Submission Form

Epping to Thornleigh Third Track Proposal. Application number SSI 5132.

I/we object to the Epping to Thornleigh Third Track Proposal and consider that the EIS is inadequate and does not address the full impact of this proposal. It will cause untold damage to the health of residents and to the fabric of the Beecroft Cheltenham Heritage Conservation Area. Do not approve this project, reconsider the alternatives and protect the community.

Figure S.6 Cross-section and elevation - New Cheltenham Station concourse building (see also S.5 for artist's impression)

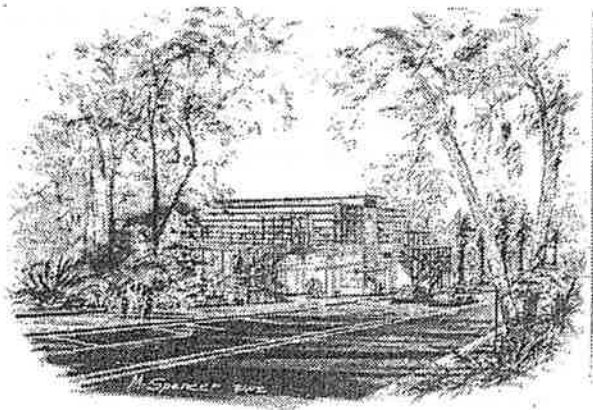
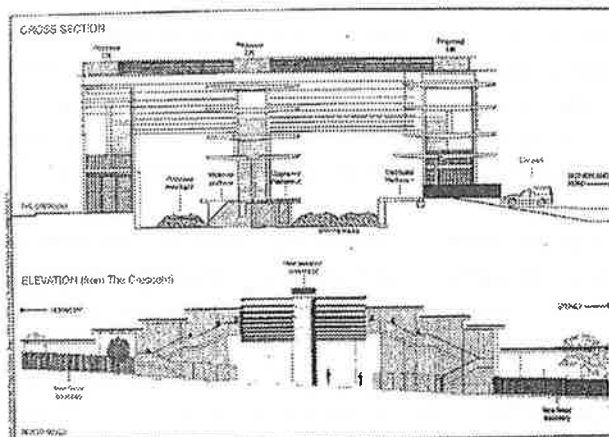
- The proposed redevelopment of Cheltenham Station shows no regard for the HCA. The visual impact of the proposed 13m high glass and steel concourse is totally unacceptable in this HCA.

We are also of the view that our privacy will be compromised due the height required to erect the structure required for the lift and overpass. Further the statement that the 3rd track will not have a significant negative impact on the heritage value of the HCA would certainly not be true for those people living in The Crescent between Cheltenham Rd and the Boulevard.
